Rosefield Solar Farm

Change Application (June 2026)

EN010158/APP/8.20
Revision 1
Change Application
June 2026
Rosefield Energyfarm Limited

DRAWING TITLE:  
**ILLUSTRATIVE LAYOUT PLANS  
 AND SECTIONS - SHEET 5 OF 9**

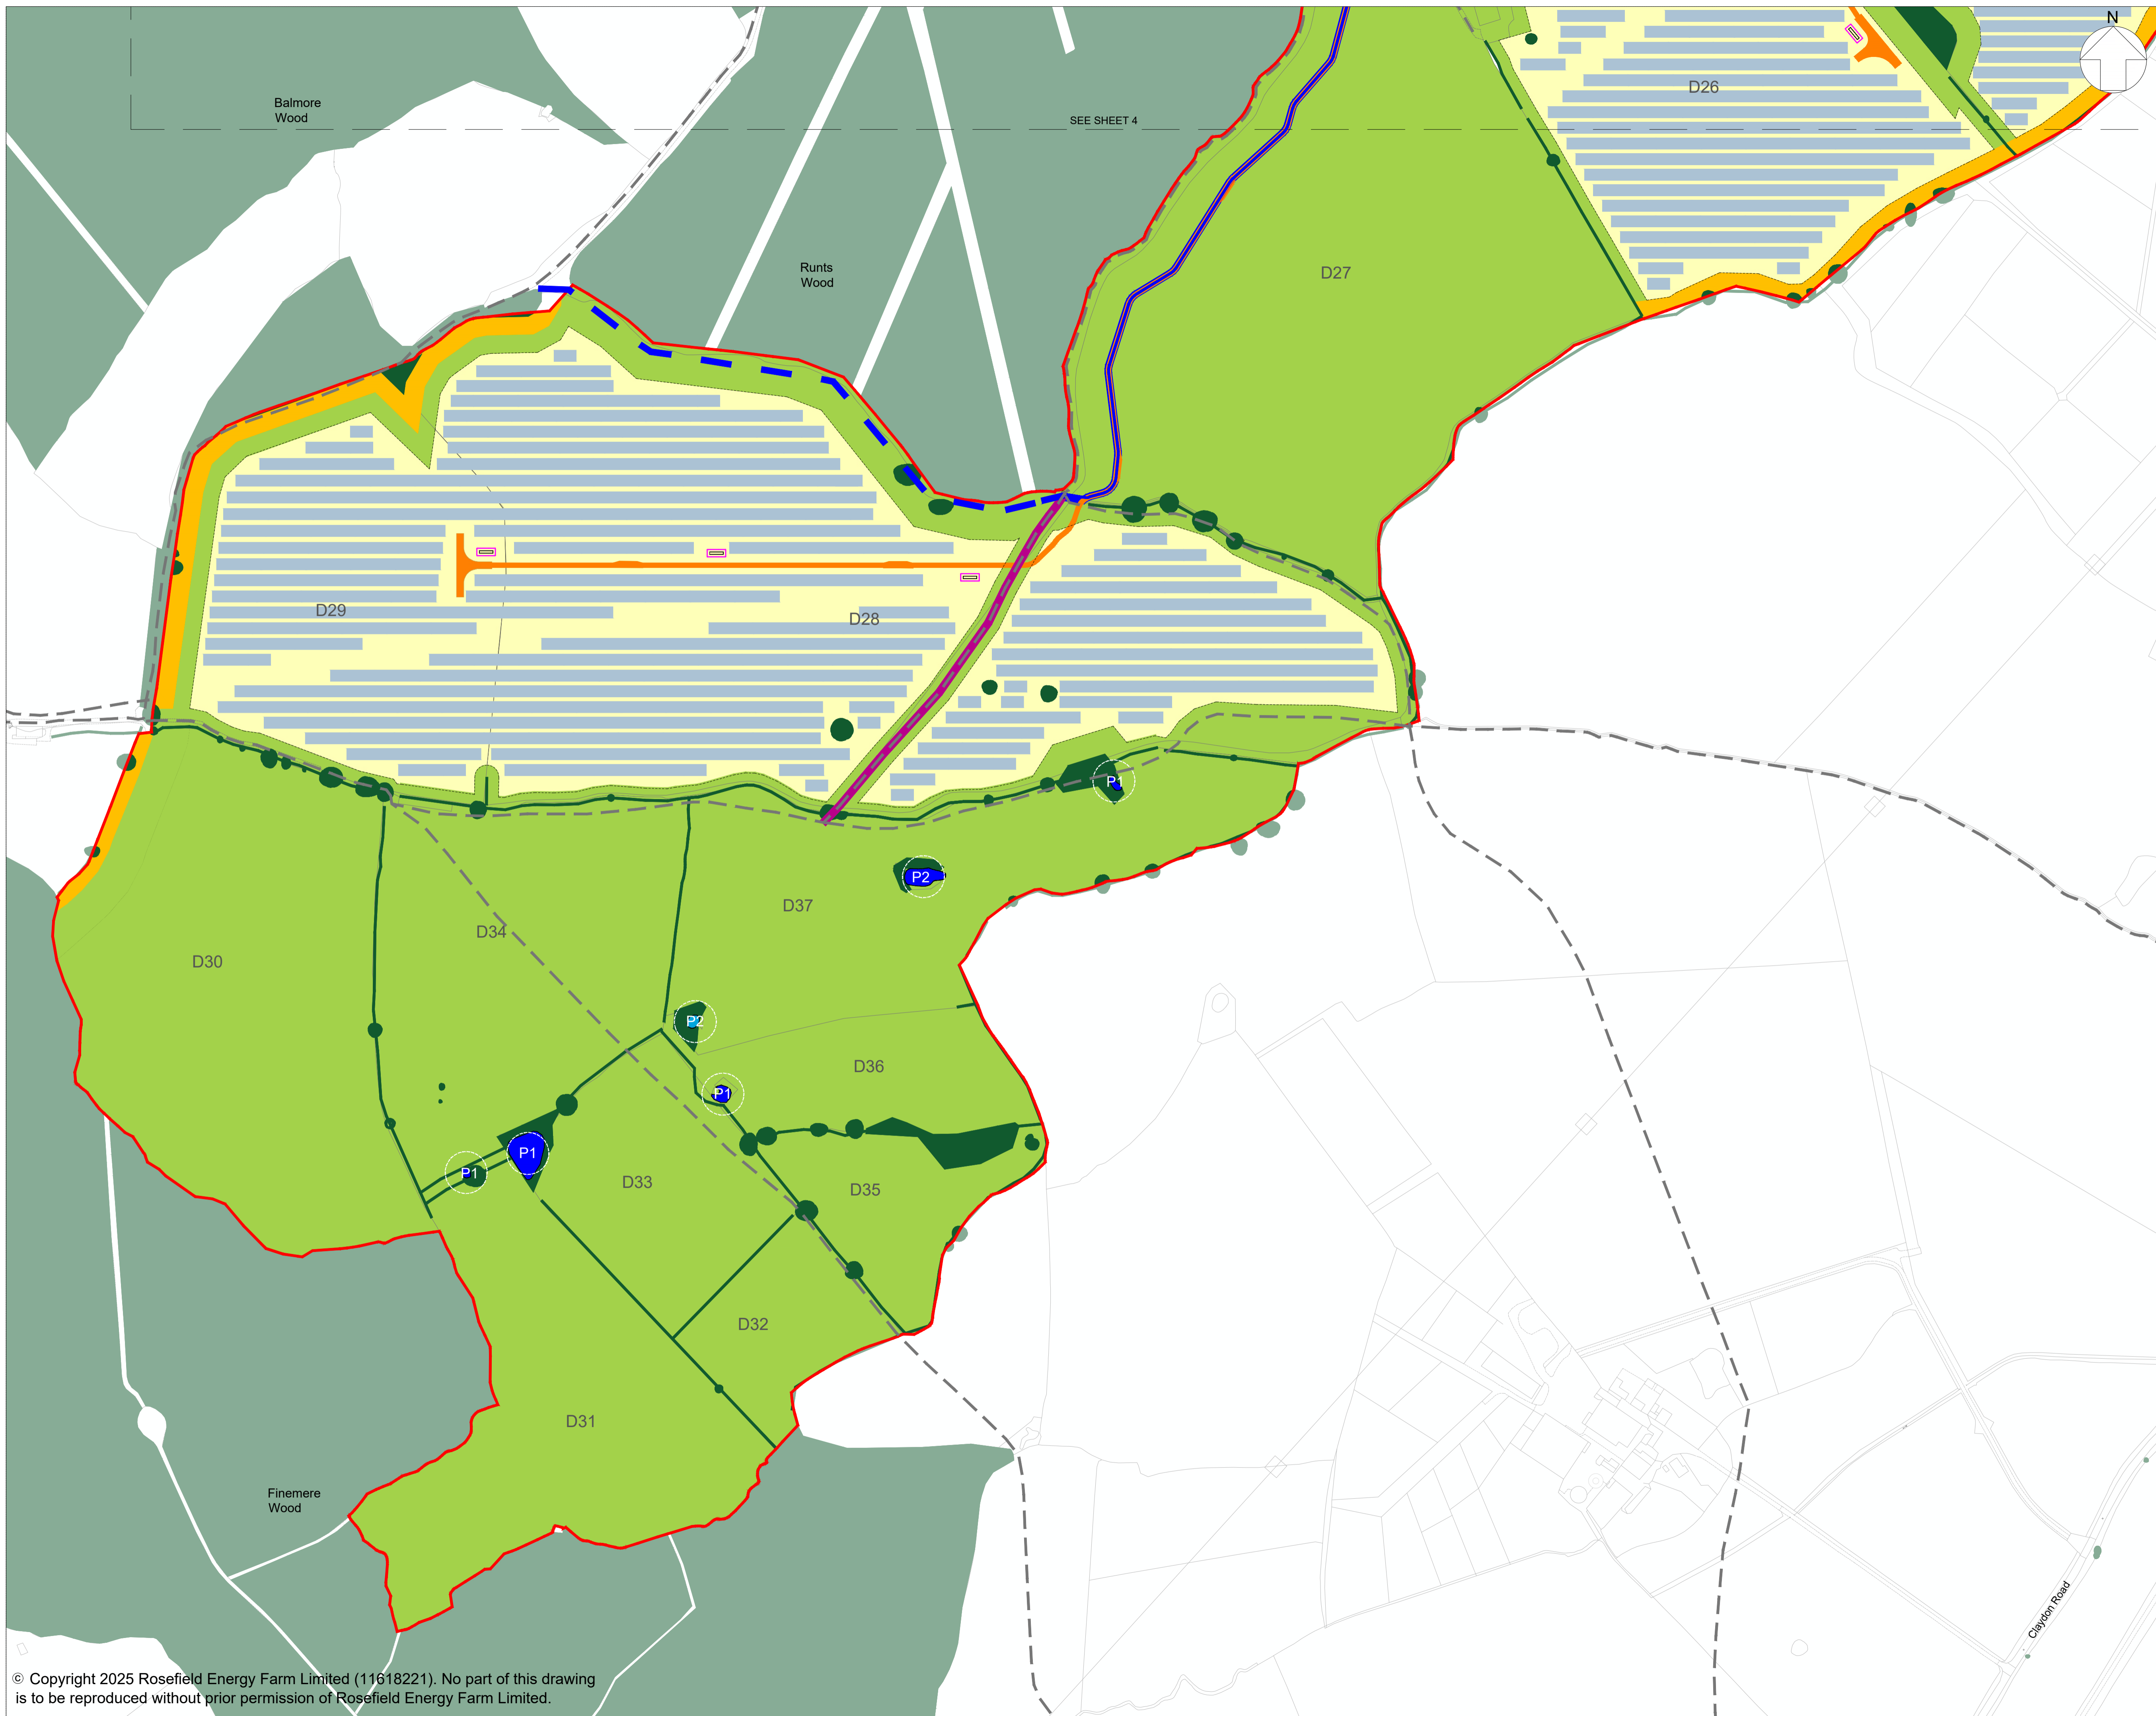
- 2.2.1. The Proposed Change would deliver a bridleway link across Parcel 2, which would be accessible to the public during the operation (including maintenance) phase of the Proposed Development. It would connect the existing dead-end PRow Bridleway (reference 'ECL/10/5') to the north of Field D27 to the PRow Bridleway (reference 'QUA/40/2' and 'QUA/40/3') that runs along the southern edge of Fields D28 and D29, addressing the "missing link" in the bridleway network identified by Buckinghamshire Council. Please refer to **Appendix A** of this report for a plan showing the location of the Proposed Change.

- 2.2.2. The proposed bridleway link would run south west along the proposed internal access track through Field D27 and then along PRow Footpath (reference 'QUA/41/1') through Field D28. The total distance of the link would be approximately 0.9km long, of which the northern section of 0.6km follows the alignment of the proposed internal access track/permissive path and the southern section of which 0.3km follows the alignment of PRow Footpath reference 'QUA/41/1'.

DCO Doc No.	DCO document name	Rev	Extent of change
EN010158/APP/2.4	Streets, Rights of Way and Access Plans	04	Components of proposed bridleway link added
EN010158/APP/2.6	Illustrative Layout Plans and Sections	04	Components of proposed bridleway link added
EN010158/APP/3.1	Draft DCO	06	Article 18, Article 21, Schedule 1(1) and Schedule 1(2)(I) updated to reflect changes required to secure proposed bridleway link

EN010158/APP/6.3.4

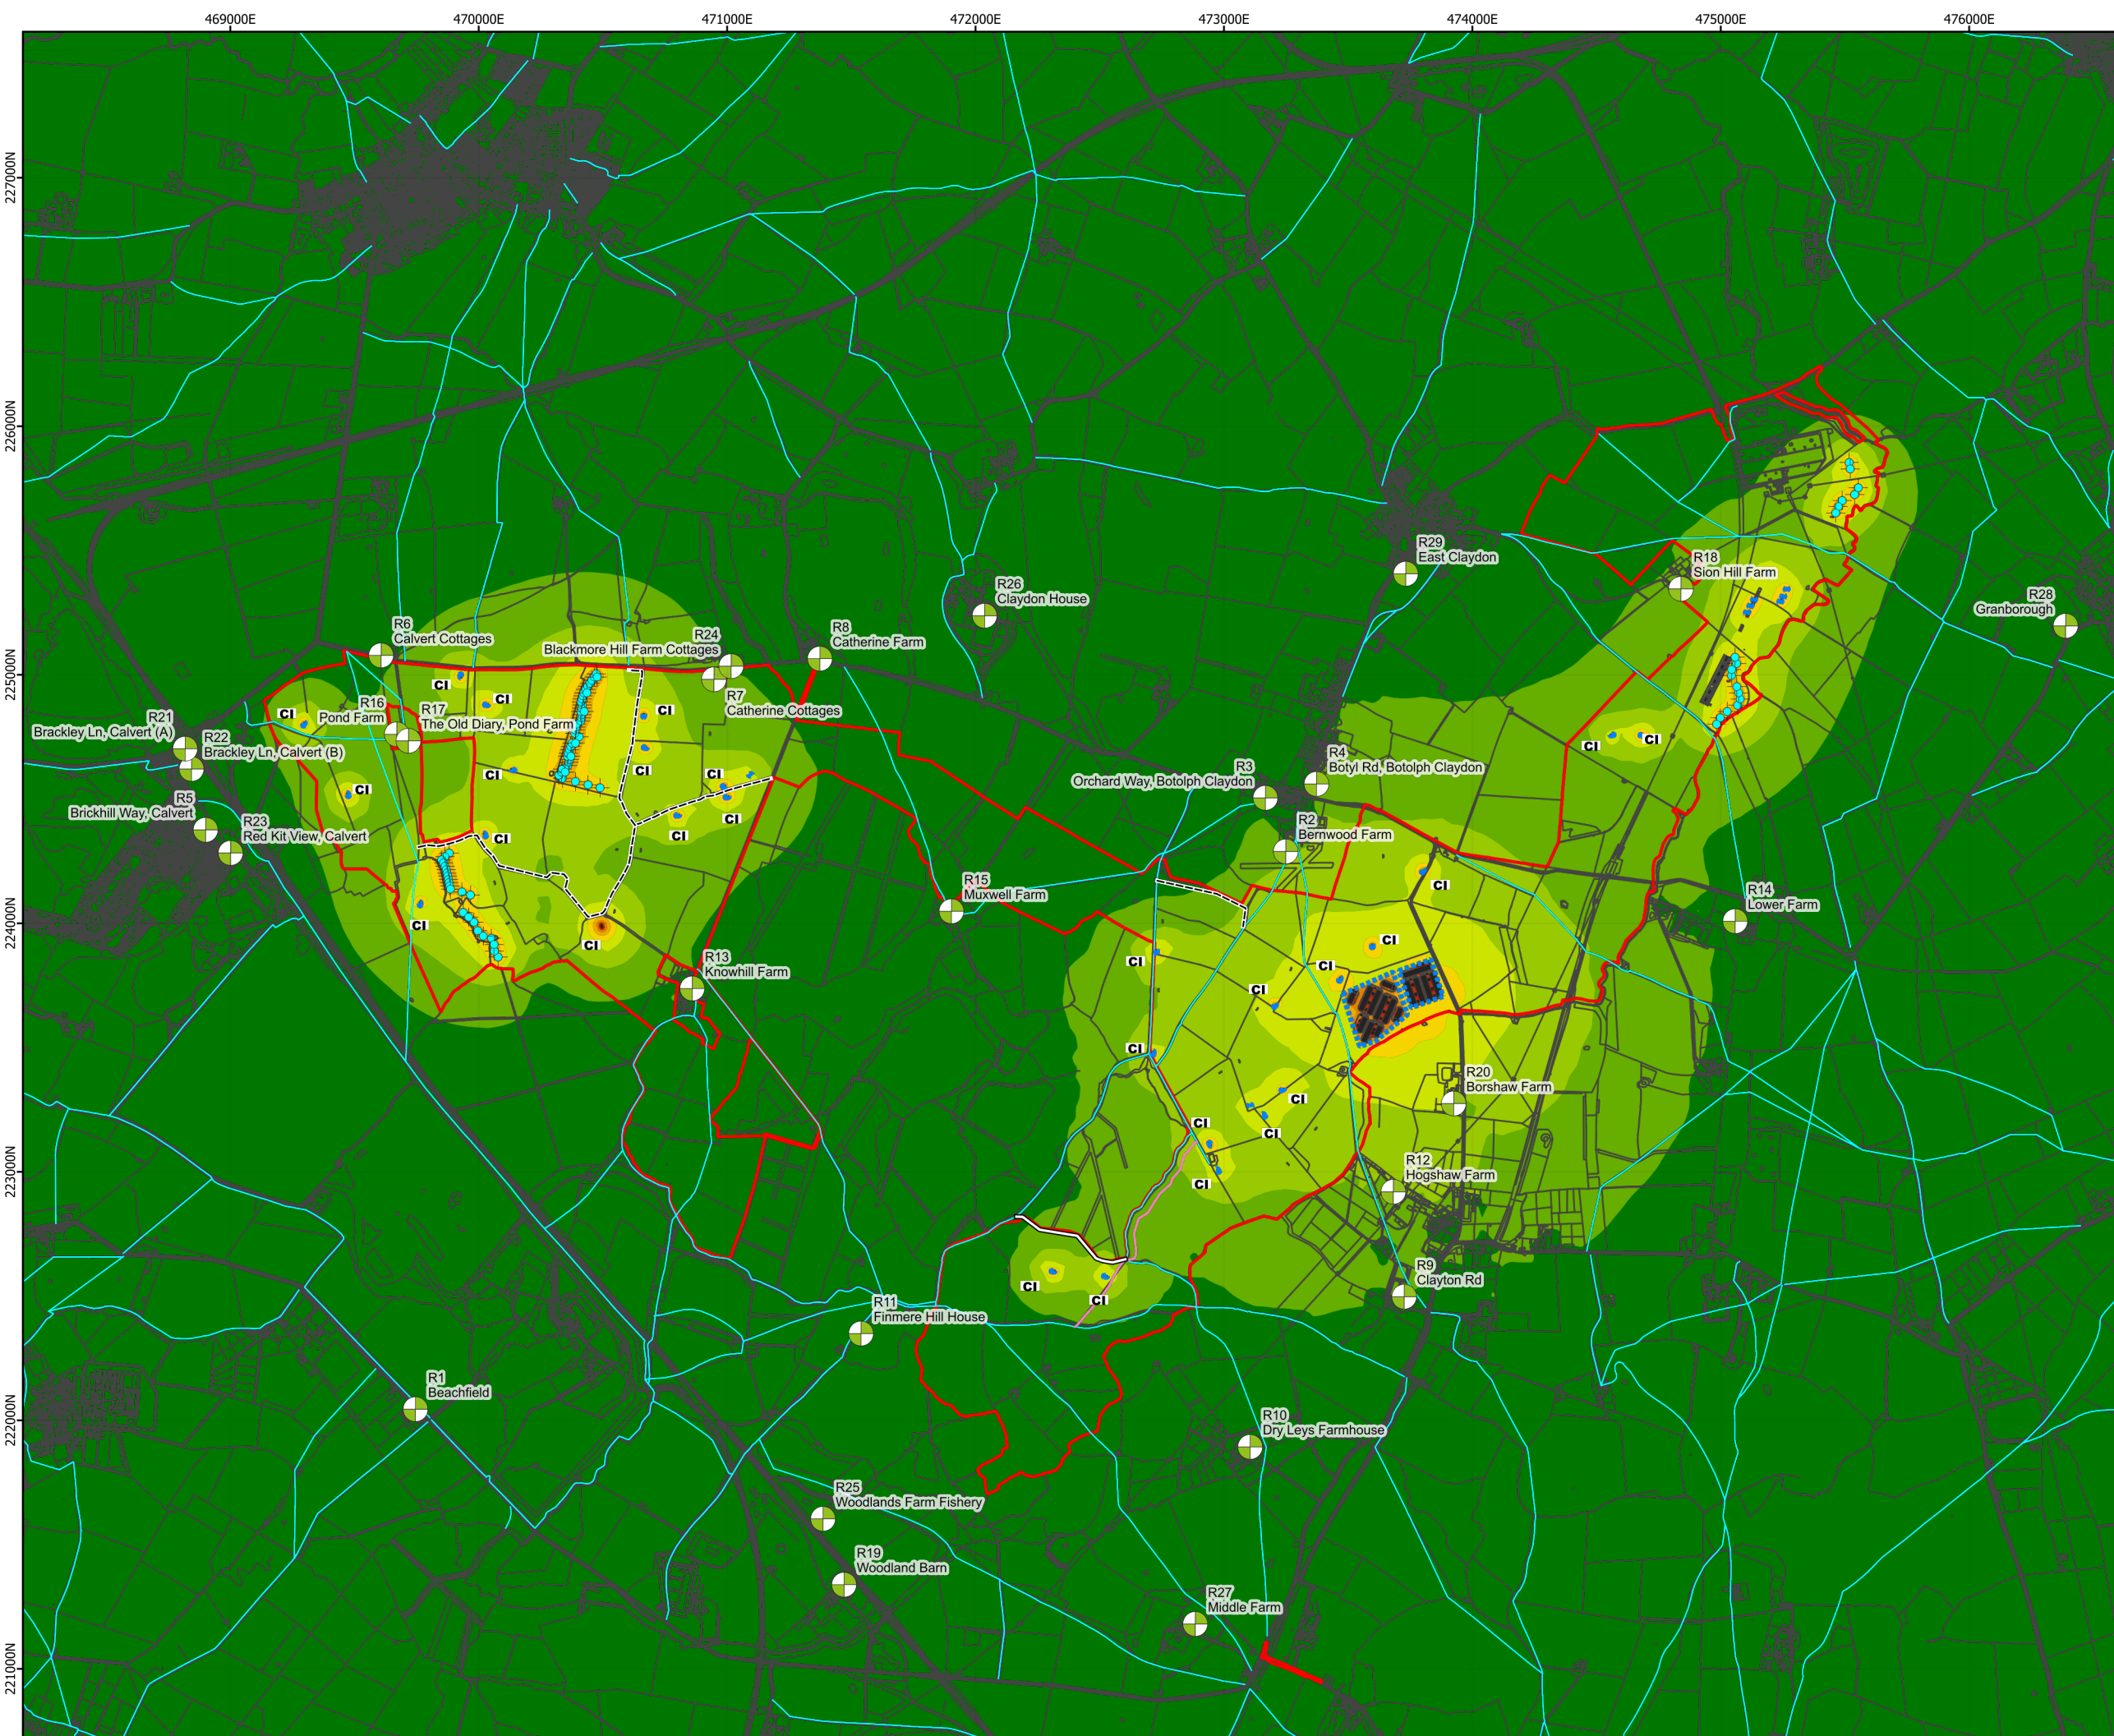
EN010158/APP/6.3	ES Volume 3, Figure 13.3: Operational Phase Noise	05	Components of proposed bridleway link added

Contours (without additional mitigation)			
EN010158/APP/6.3	ES Volume 3, Figure 13.4: Operational Phase Noise Contours (with additional mitigation)	05	Components of proposed bridleway link added
EN010158/APP/6.4	ES Volume 4, Appendix 5.5: Health and Wellbeing Summary Statement	05	Paragraphs 3.6.12 and 6.1.27
EN010158/APP/7.6	Outline Landscape and Ecological Management Plan	04	Paragraphs 1.1.2, 3.1.8, 3.3.14, 3.3.17, 5.1.3 and Appendices 1, 2 and 5 updated to reflect components of proposed bridleway link.
EN010158/APP/7.8	Outline Rights of Way and Access Strategy	05	Paragraphs 1.1.2, 5.1.3, 5.1.5, 5.1.6, 8.1.1, 8.1.2, 9.1.1, section 7.2, and Plate 7.2 updated to reflect components of proposed bridleway link.
EN010158/APP/8.1	Schedule of Changes to the Draft DCO	05	To capture the changes made to the Draft DCO [EN010158/APP/3.1.6] to secure proposed bridleway link
